Botley West Solar Farm Ref: EN010147 -

Deadline 2: June 27th 2025 – Subsequent to Questions (ExQ1)

For the attention of the Planning Inspectorate. Our reference number: RR 0413

Revision of Submission Reference Number: 36569

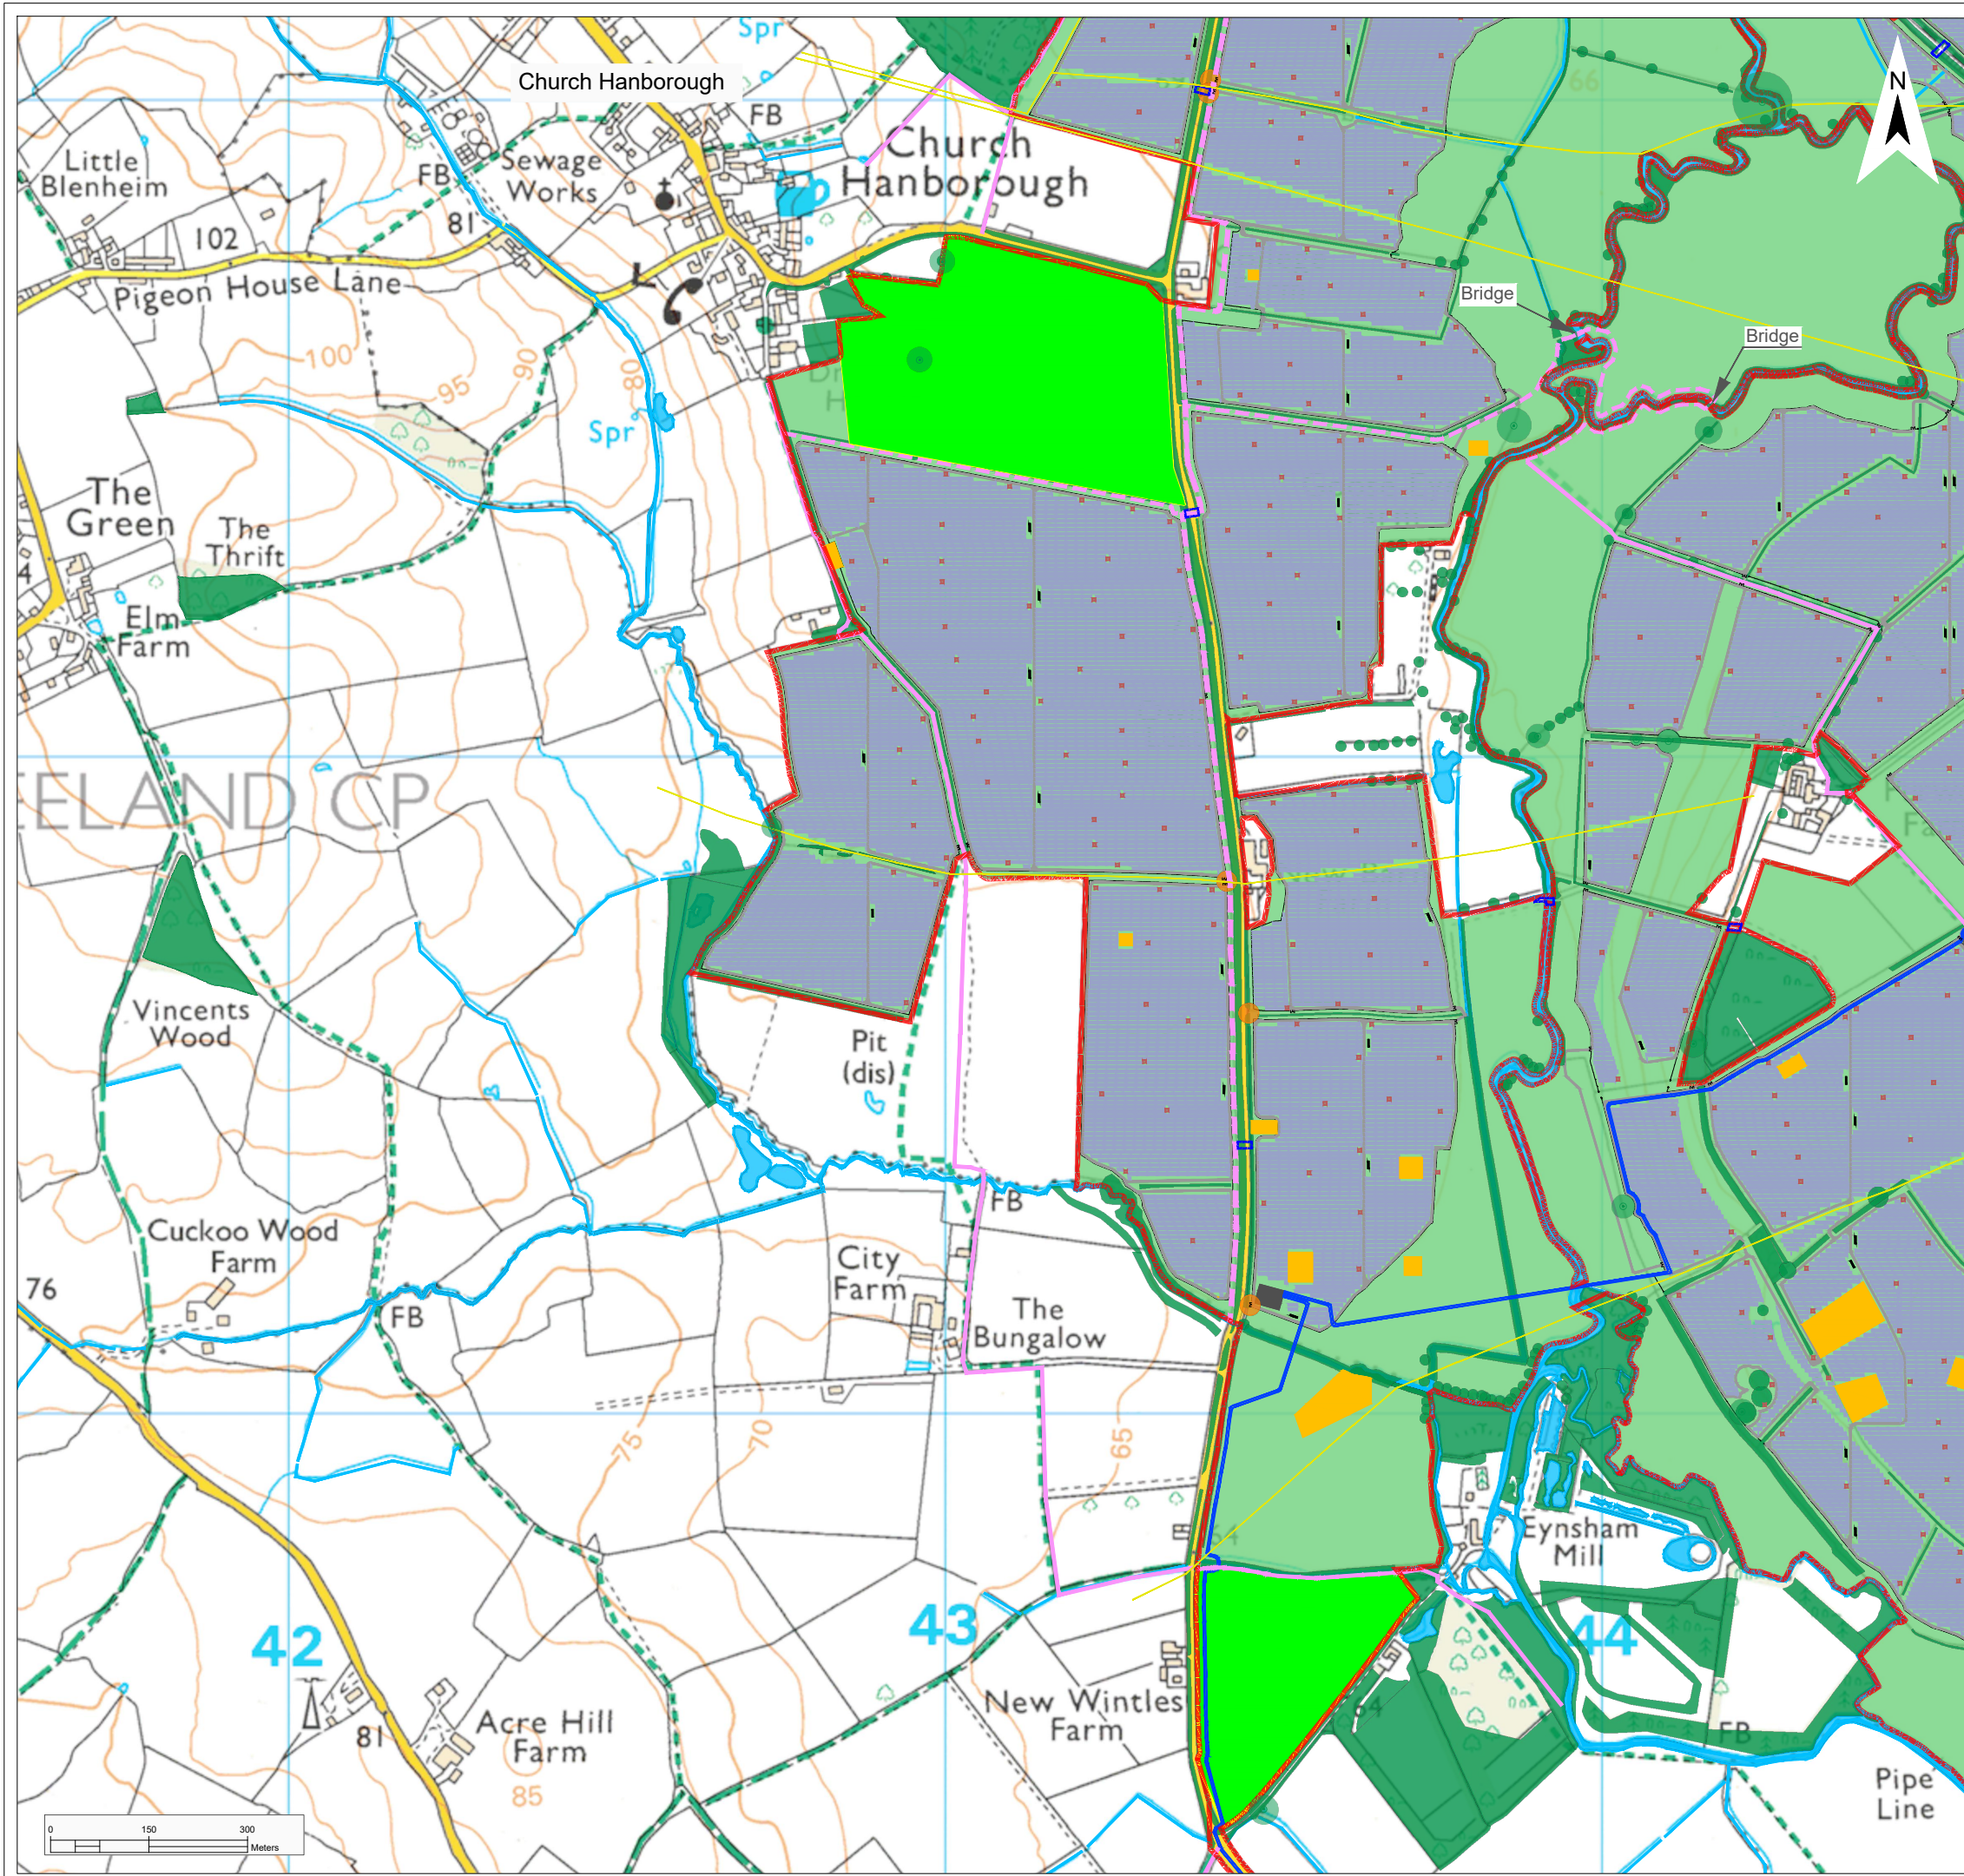
Illustrative Masterplan – Figure 2.2A (with 2.2B & 2.2C top right) - Bladon & Begbroke:

The proposed northern block of the Central Solar Farm fills most of the 2 km of farmland between Bladon and Begbroke villages, with ancient Bladon Heath Wood to its south and Oxford airport to the N-E beyond the A44. The proposal comes too close to the linear Bladon village, an adjunct of Blenheim Park associated with Winston Churchill. To provide the village with breathing space **arrays on the fields between Bladon village and the village recreation footpath to its east should be omitted, together with an arc east of the southern village extension [Figure 2.2A western side with 2.2B] .**

Arrays are shown imposing upon Begbroke village which opens out westwards beyond the small ancient Begbroke church towards countryside and woodland, and the well-used dual footpaths along the north side of Bladon Heath Wood. To conserve this valuable characteristic of the setting of Begbroke there should be no solar panels within 200m of the north side of Begbroke village, a mere 3 minutes leisurely walk, nor in the two fields to the west of the village, the western of which is ground rising from 'Shakespeare's Way' long distance recreational footpath. There should not be solar panels on the narrow strip of land between the dual footpaths linking Begbroke with Bladon.

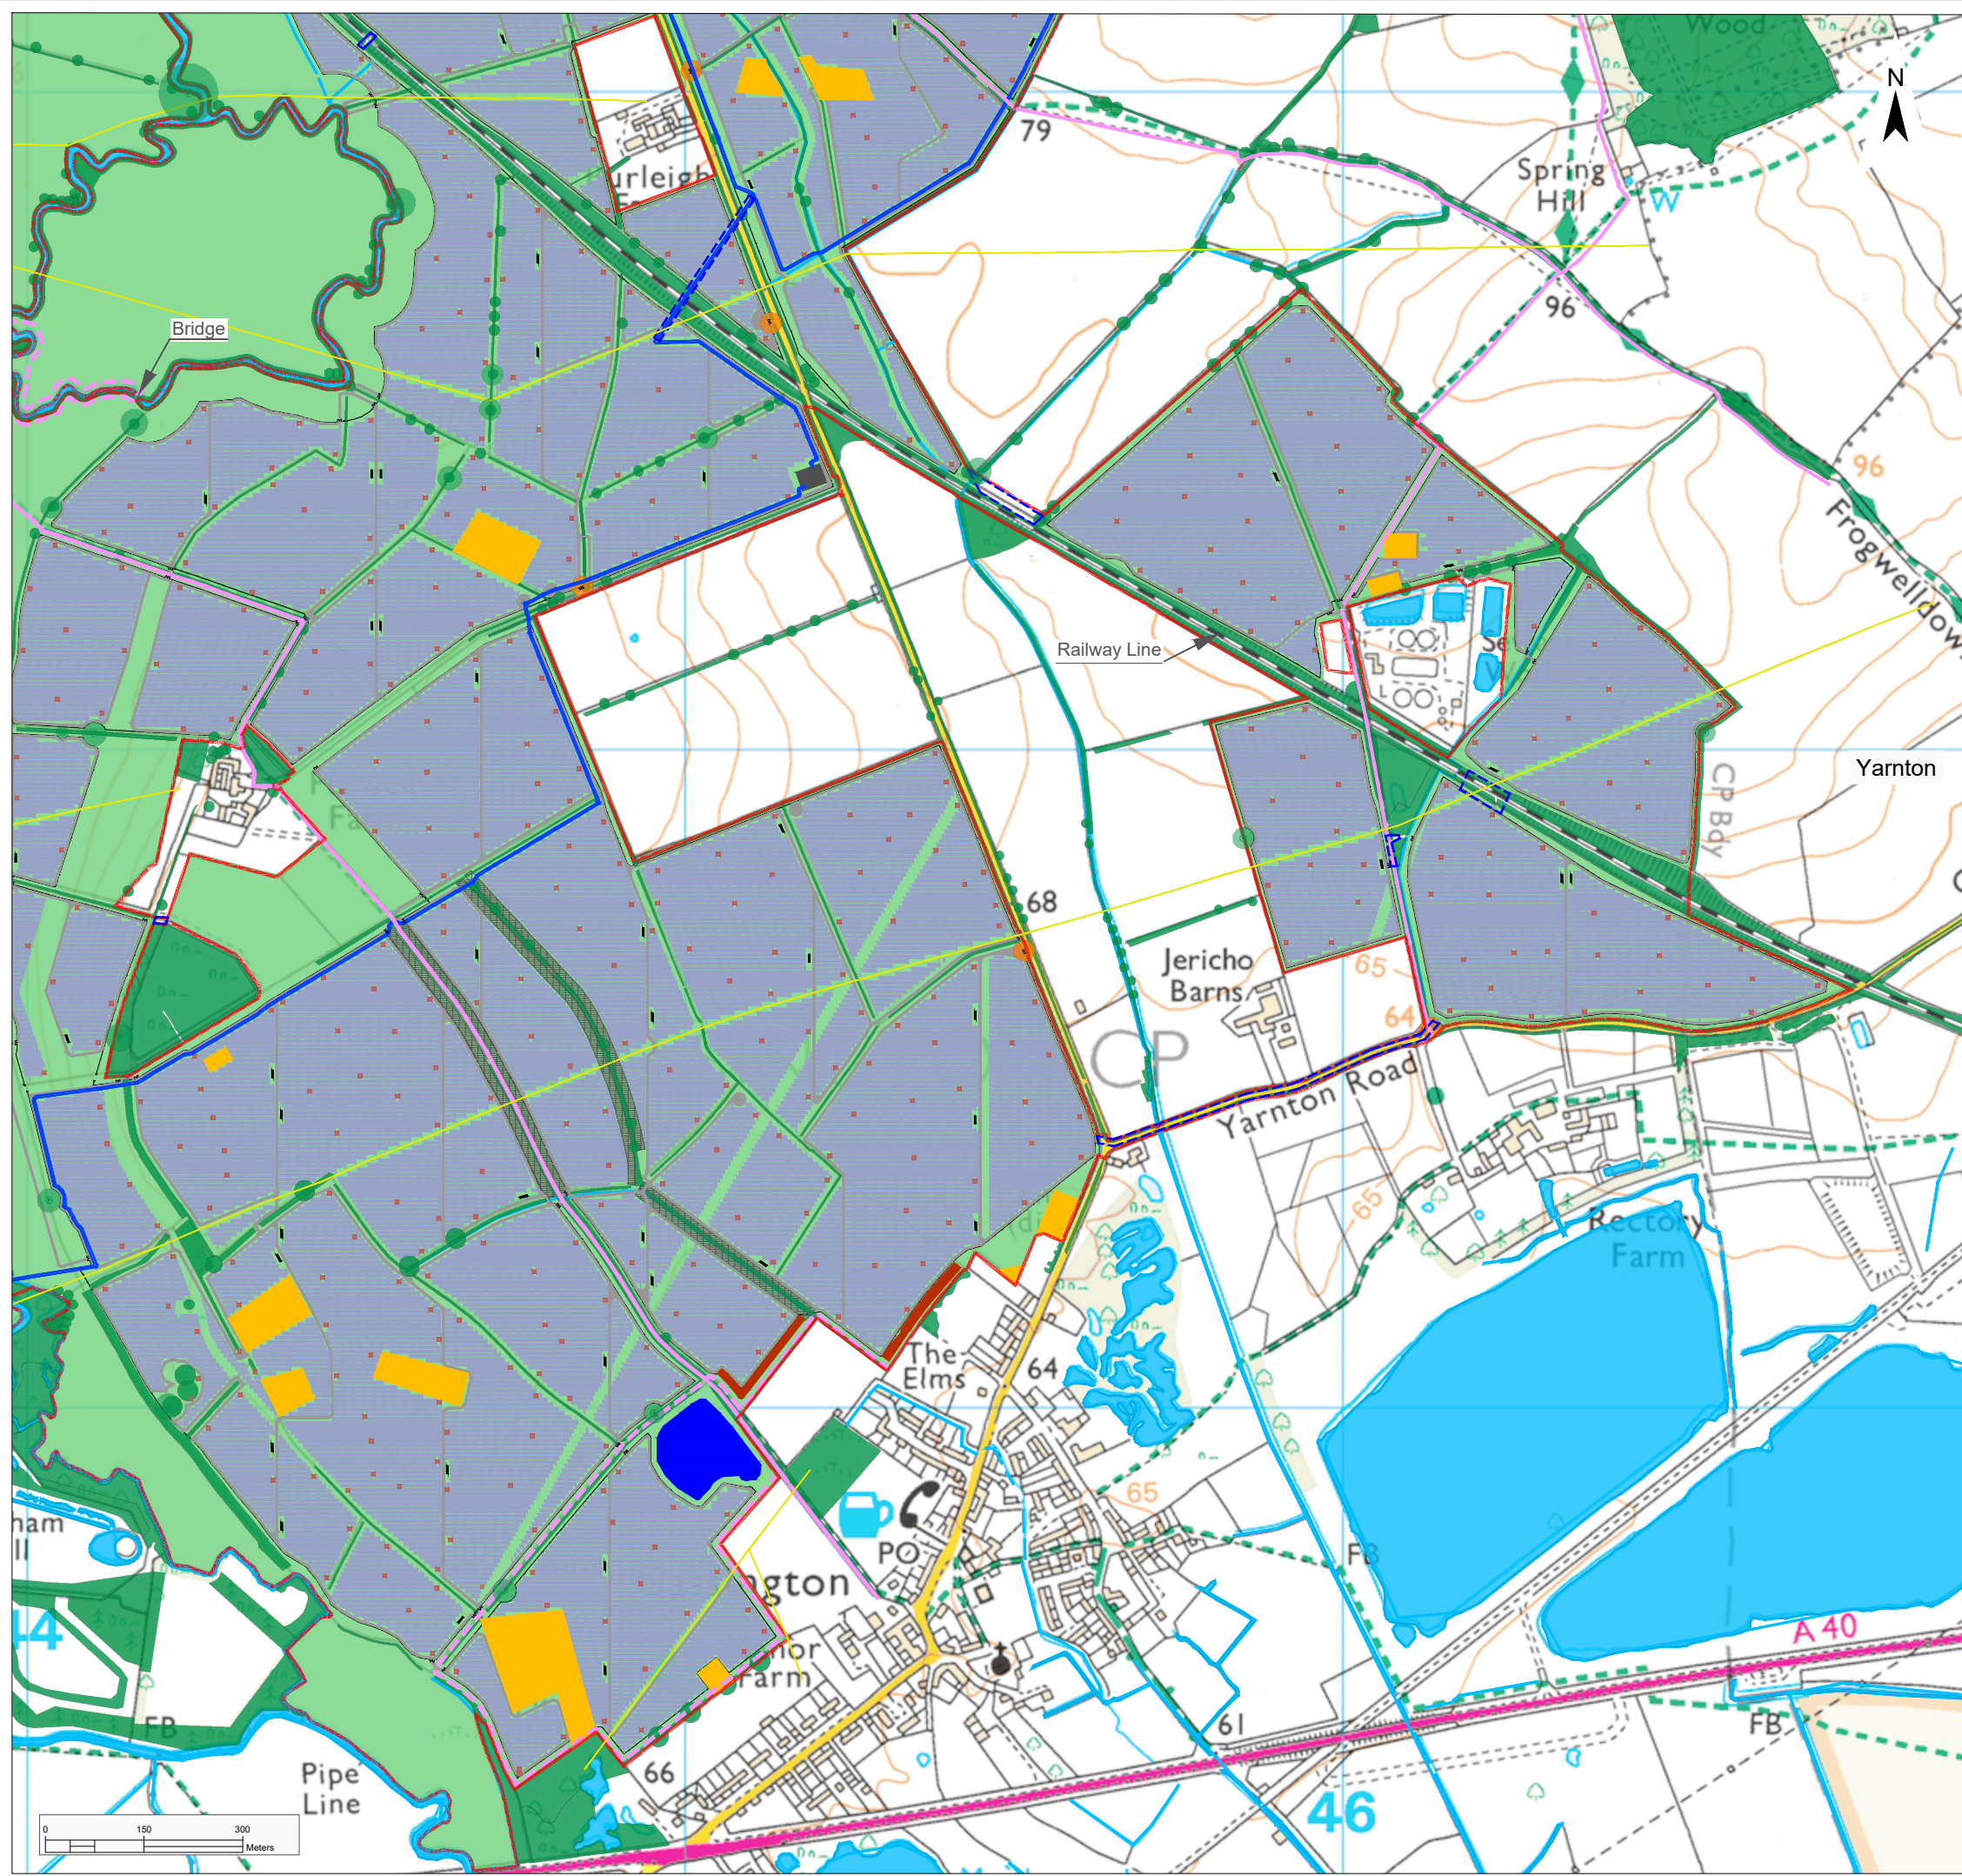
Much of the 3km long central block alongside the railway, including the slightly detached surroundings of a sewage works (2.2C), and on either side of a minor road, is on a kind of plateau of gently rising ground where solar arrays could be made comparatively inconspicuous from without if surrounded by tall wide dense hedges. This applies also to its detached northern end (Figure 2.2B) which, though a place where a solar farm would have a detrimental

Illustrative Masterplan – Figures 2.2 C,D,F – Evenlode Valley Eastern Escarpment:

The eastern edge of the lovely Evenlode valley is a very unsatisfactory part of the Applicants' proposals. It is unacceptable to place solar panels on the steep west facing escarpment along the east side of the Evenlode valley, itself wisely excluded from proposed development. It is as if the topography of the landscape has not been analysed, as if no independent landscape mind has been involved. **There should be no solar panels on any of the escarpment on the east side of the Evenlode Valley.**
